Nyton Lodge,
Nyton Road,
Westergate,
Chichester,
PO20 3UL

RE: AL/49/20/PL – Nightingale Cottage and Byfields

I write to object to this application on the grounds set out below.

ACCESS DESIGN:

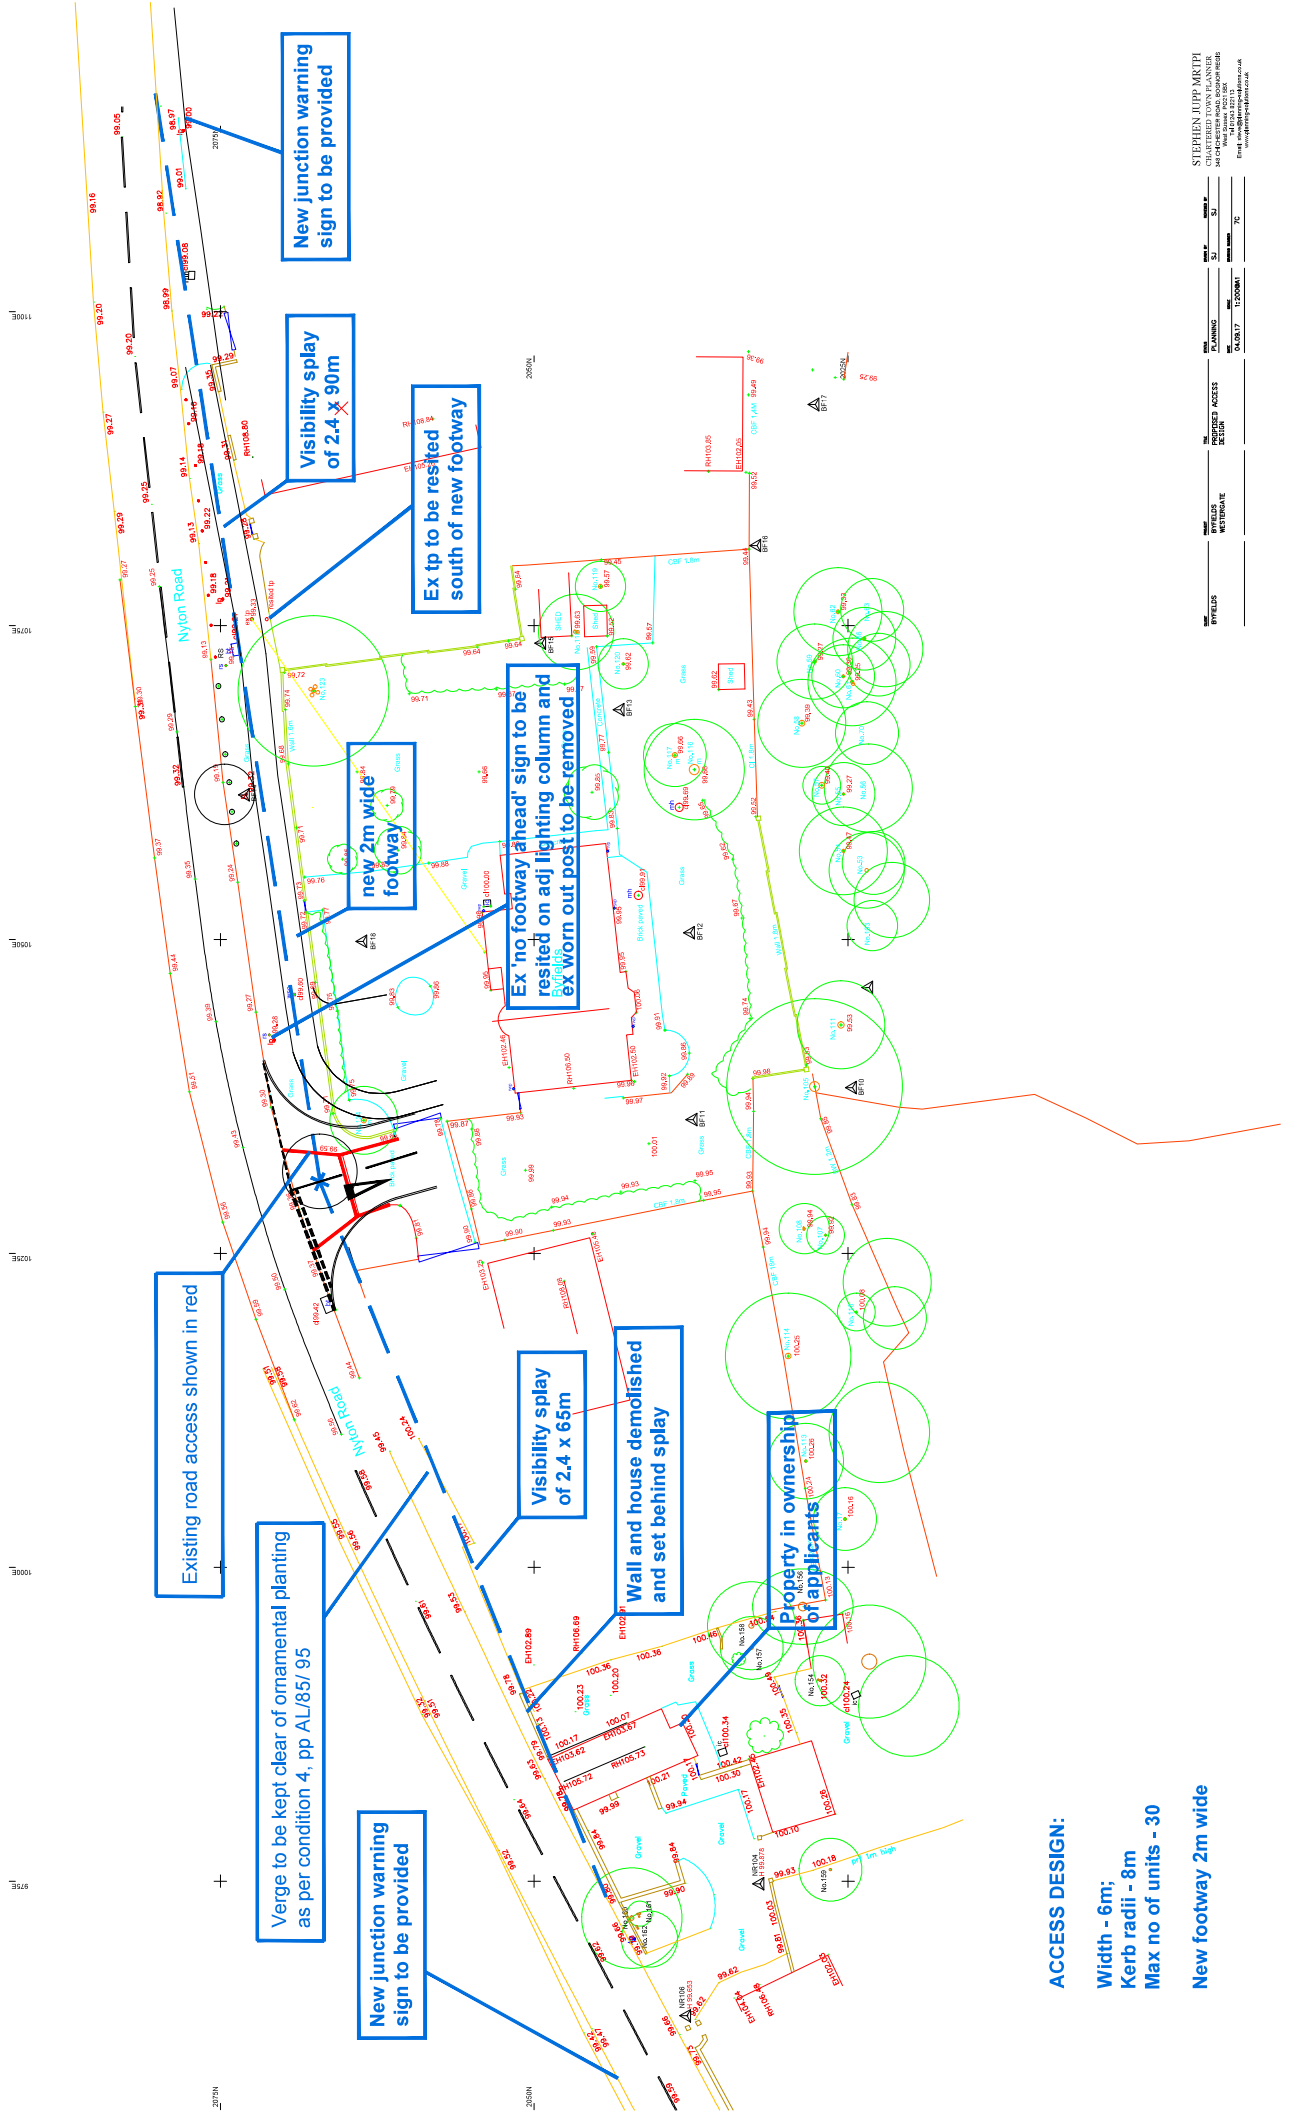
Were the planning committee minded to approve an application for this site, provision of a pedestrian footway would be essential. The Design Statement p23 says a new 2m wider footway will be installed, but this is only at Byfields, not at Nightingale Cottage. My husband and I and our children regularly walk this narrow section of the road and speeding traffic is a constant danger. Traffic surveys have shown cars not infrequently reach 50 to 60 mph at this point. It is a particular danger from the East because people put their foot down after leaving the Basmati junction and have gained speed by this point.
